RFI ITEMS

BCD Recommendations	RFI Response Comments										
1. The comments on coastal issues provided by BCS on 27 May 2021 be addressed.	We understand the comments relating to coastal issues provided by BCS on 27 th May 2021 relate to addressing Clause 13 and Clause 14 of SEPP (Coastal Management) 2018.										
	SEPP (Coastal Management) 2018 has now been repealed and its provisions rolled into SEPP (Resilience and Hazards) 2021. The equivalent provisions to Clause 13 and Clause 14 of SEPP (Coastal Management) 2018 within SEPP (Resilience and Hazards) 2021, are Clause 2.10 and Clause 2.11.										
	Importantly we note that most of the project site is clear of the Coastal Use Area and the Coastal Environment Area. In the north-western corner of the site an irregular lot boundary partially intersects the Coastal Use Area and Coastal Environment Area. Further, only a relatively small area of Phase 11 (estimated as some 23,905m ²) falls within the Coastal Environment Area. Refer Attachment 2 – G&S Response Letter dated 28 th May 2025 for the location of the Coastal Use Area and Coastal Environment Area as it relates to the site and extract areas.										
	Clause 2.10 and Cla

SECTION C
1:150 AT A1

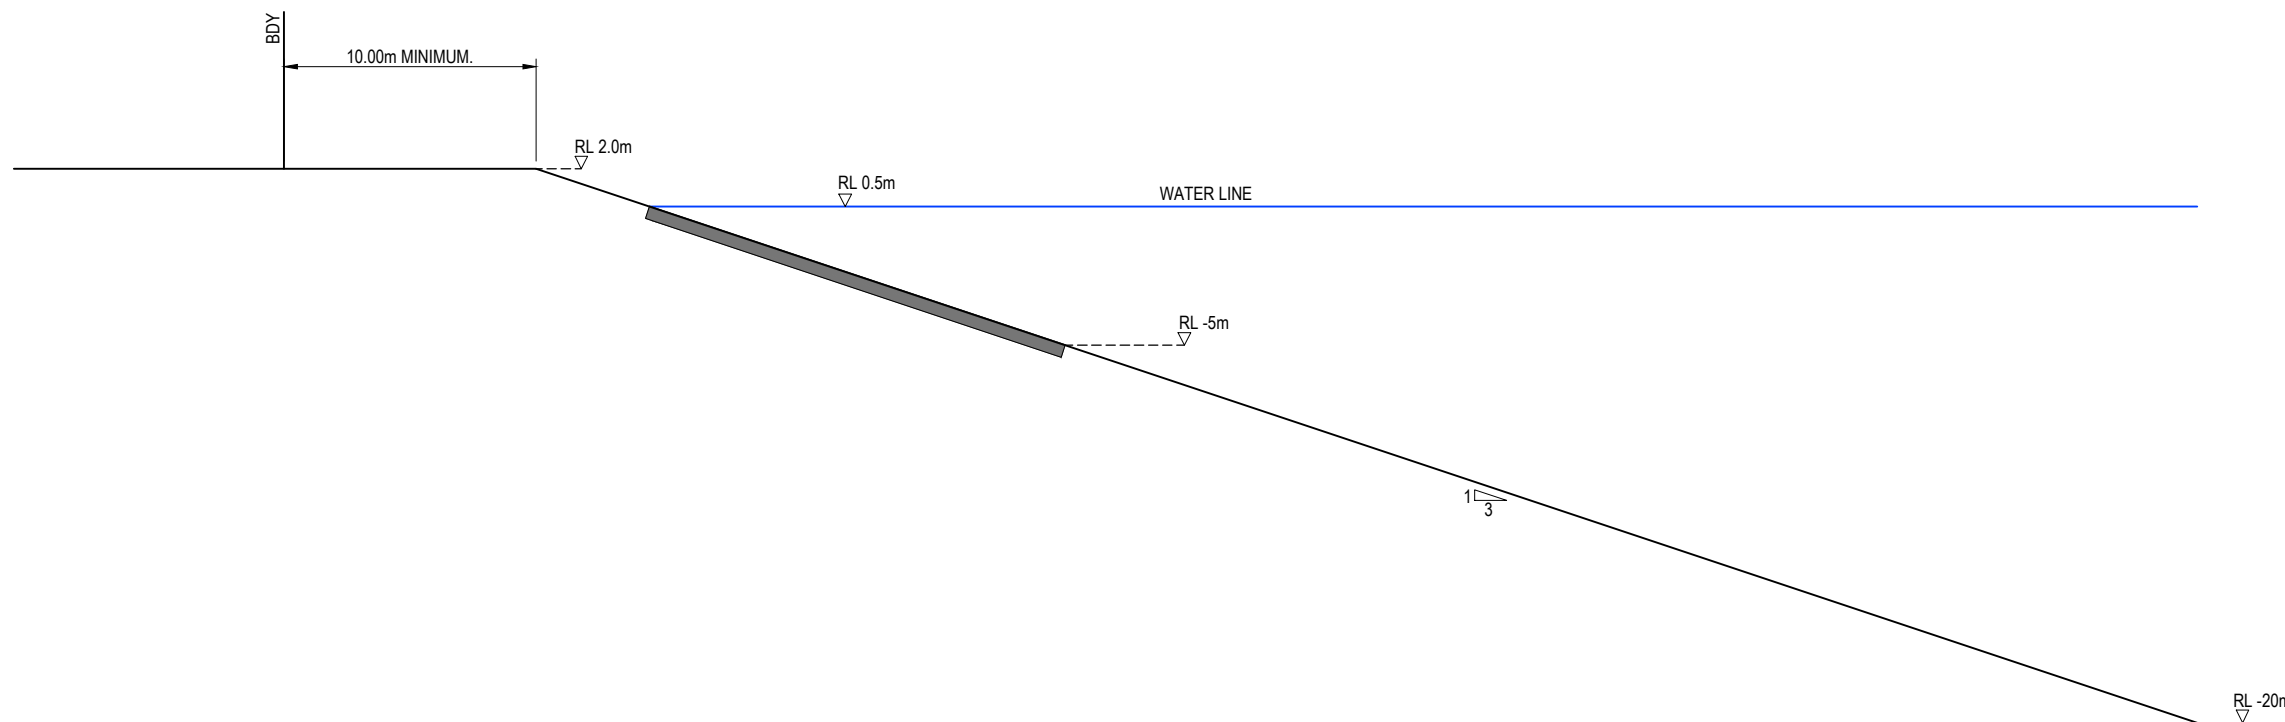
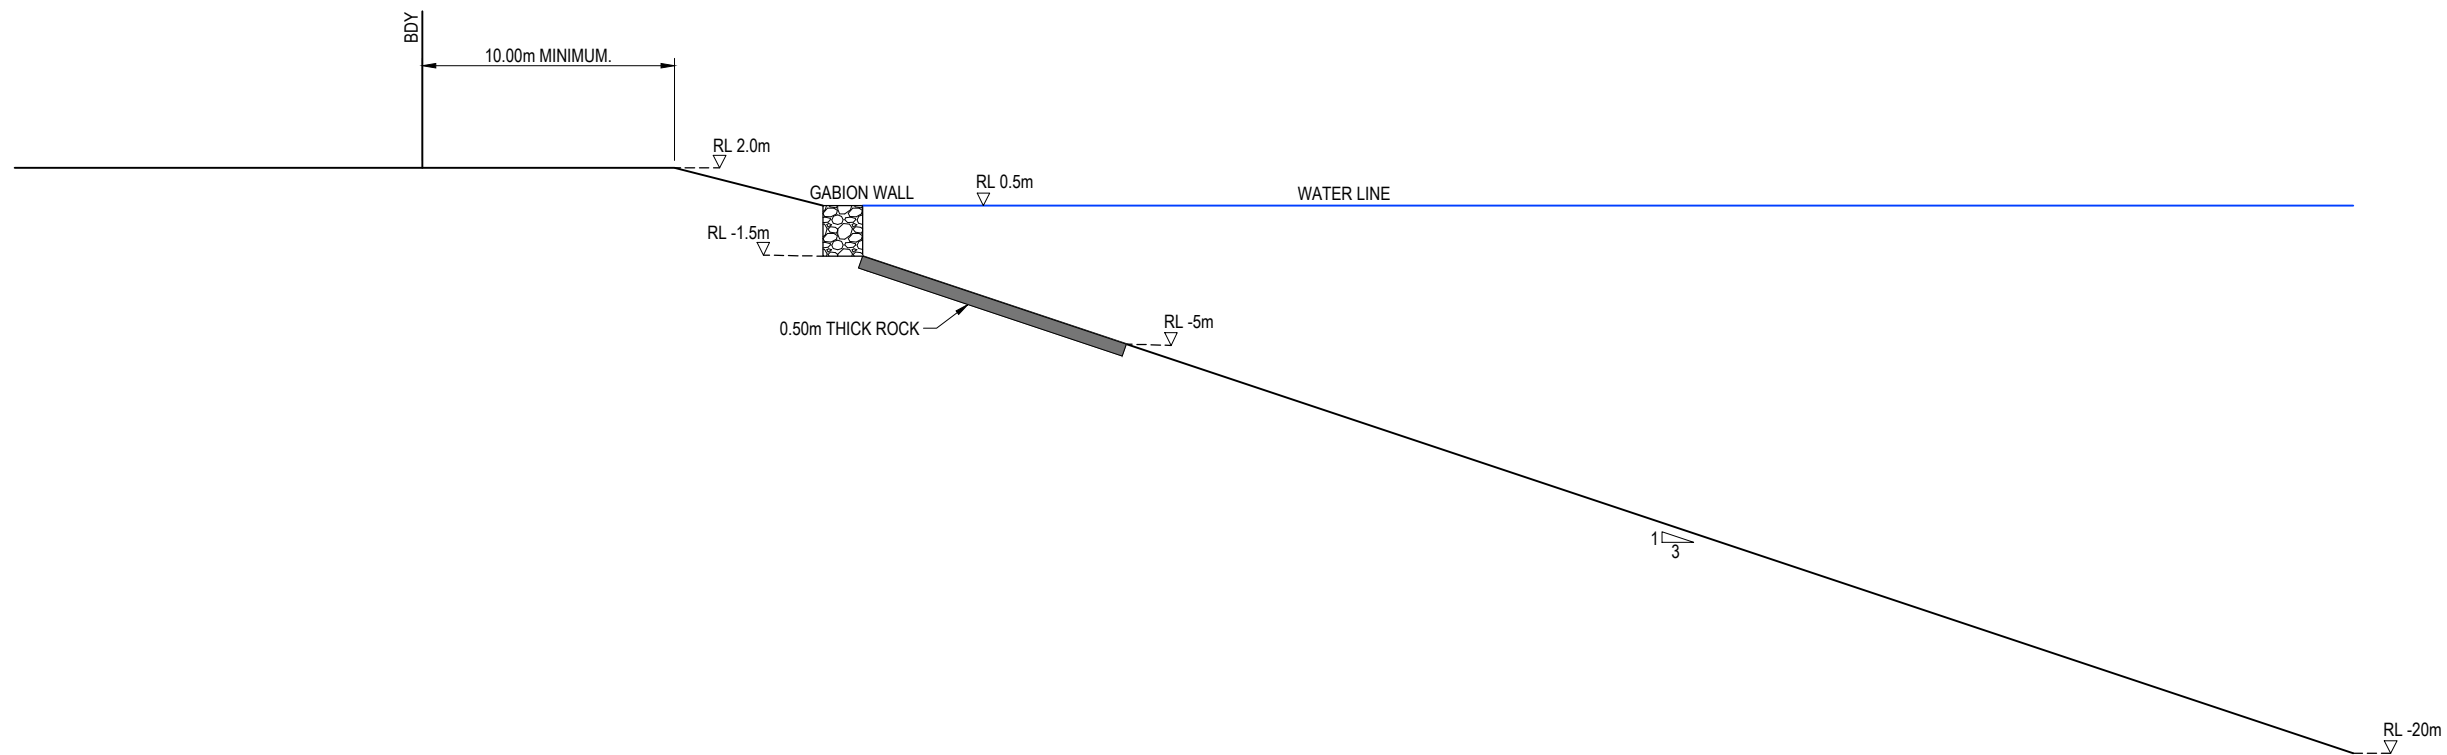
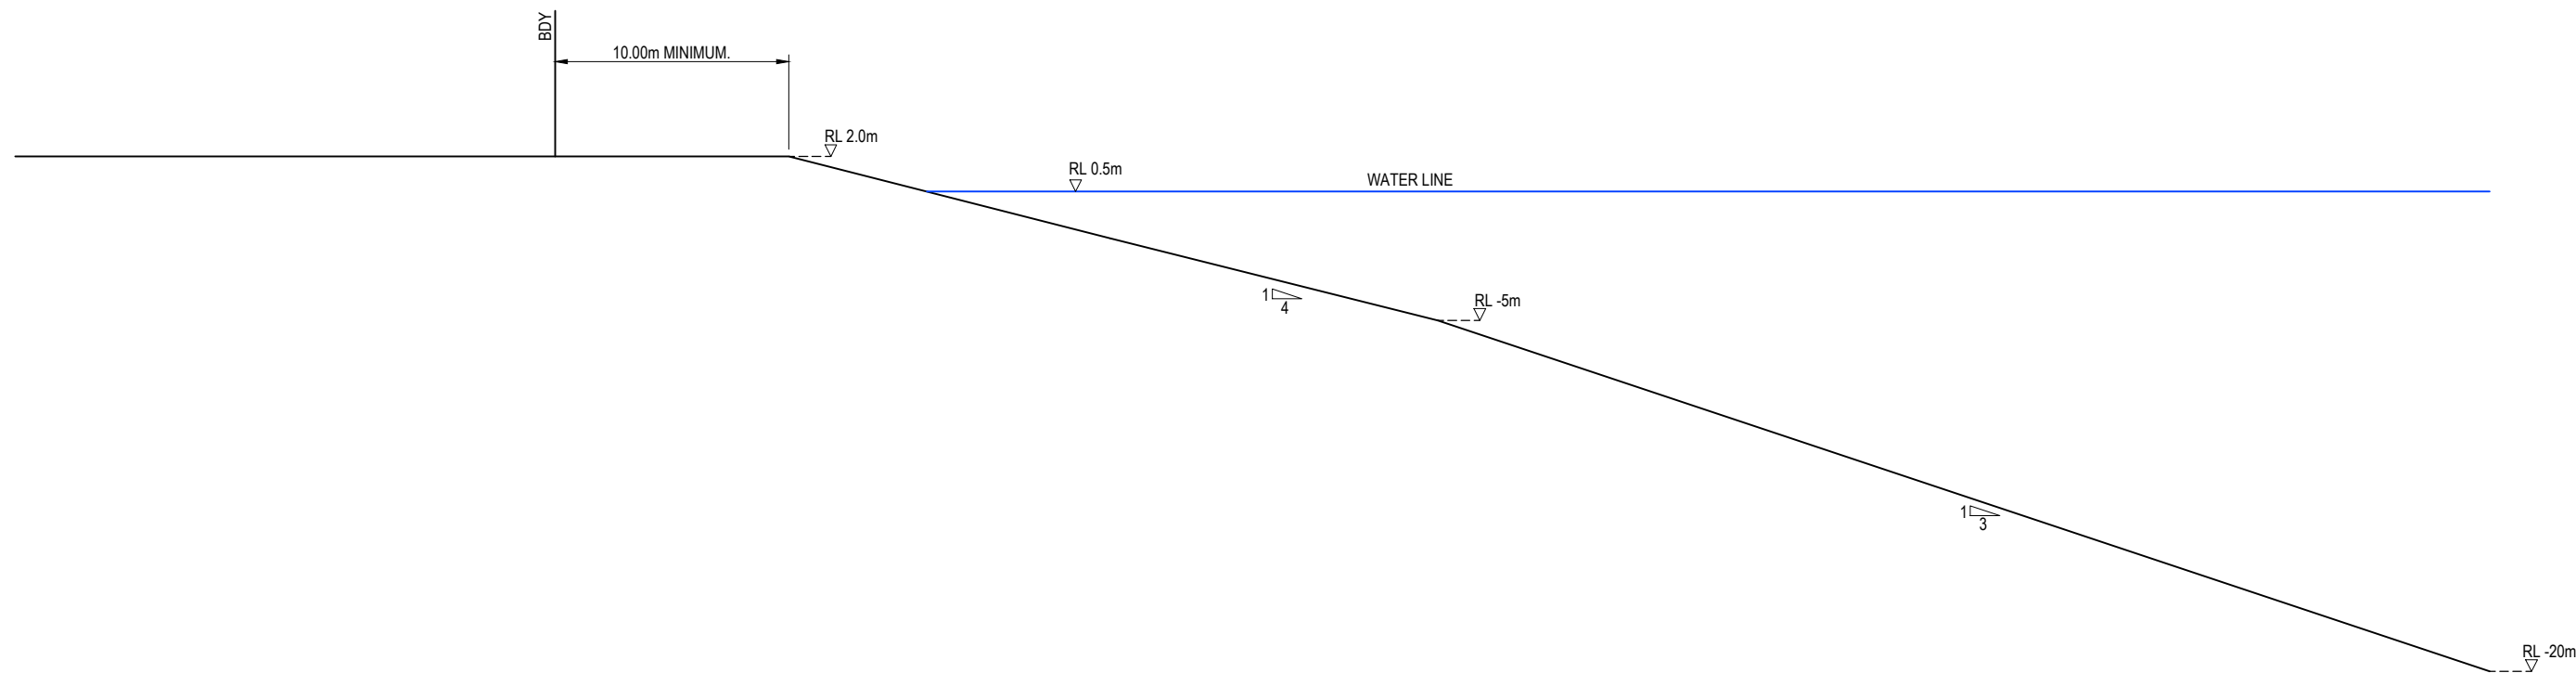
11. Appropriately scaled and dimensioned plans and sections be provided that demonstrate what will be achieved for the rehabilitation works both for the riparian area and wetland area.	Please refer to Attachment 8 – Revised Lake Bank Profiles
